Application for a non-material amendment following a grant of planning permission.

Erection of a first floor and entrance porch	
Reference number:	FP/260/19/HH
Date of decision	03/03/2020

Change to first floor cladding specification

Drawing P01b November 2019 Scale 1:100 @ A3
Proposed Drawing - Ground Floor Plan & Elevations

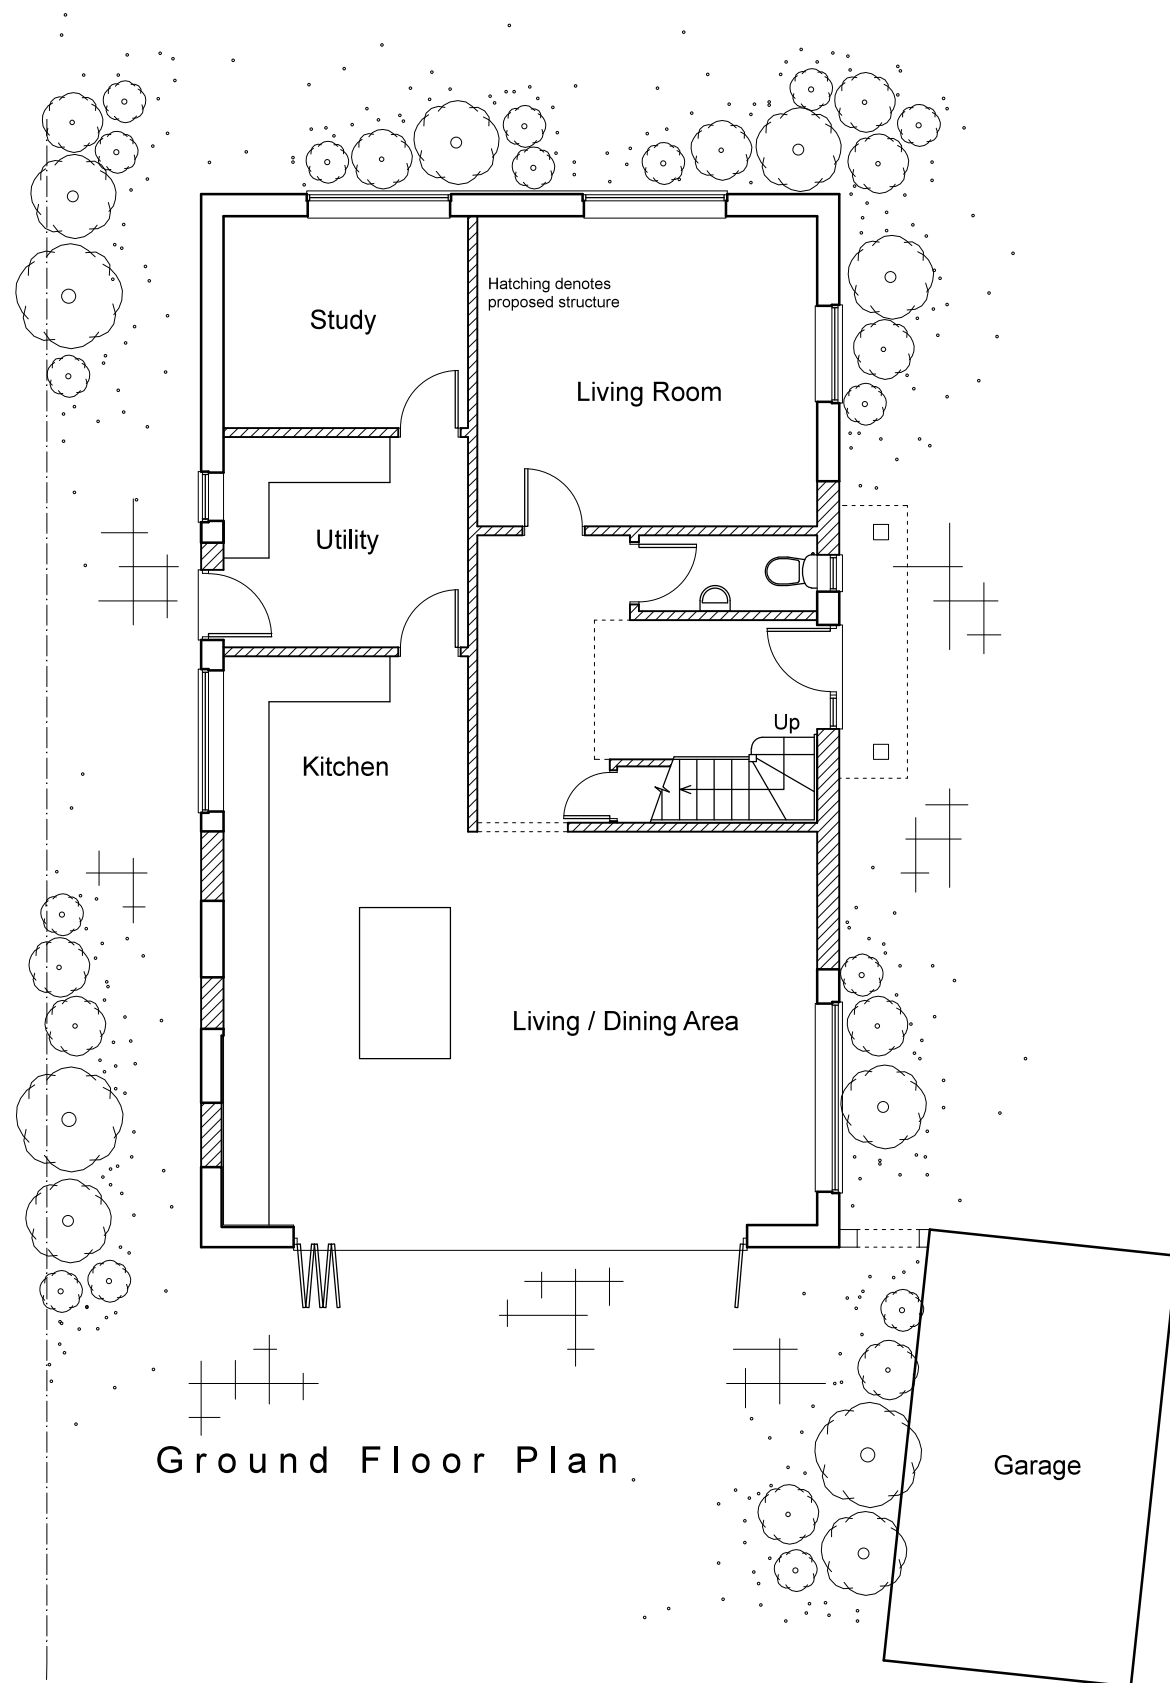
Change of specification to comply with Building Regulations
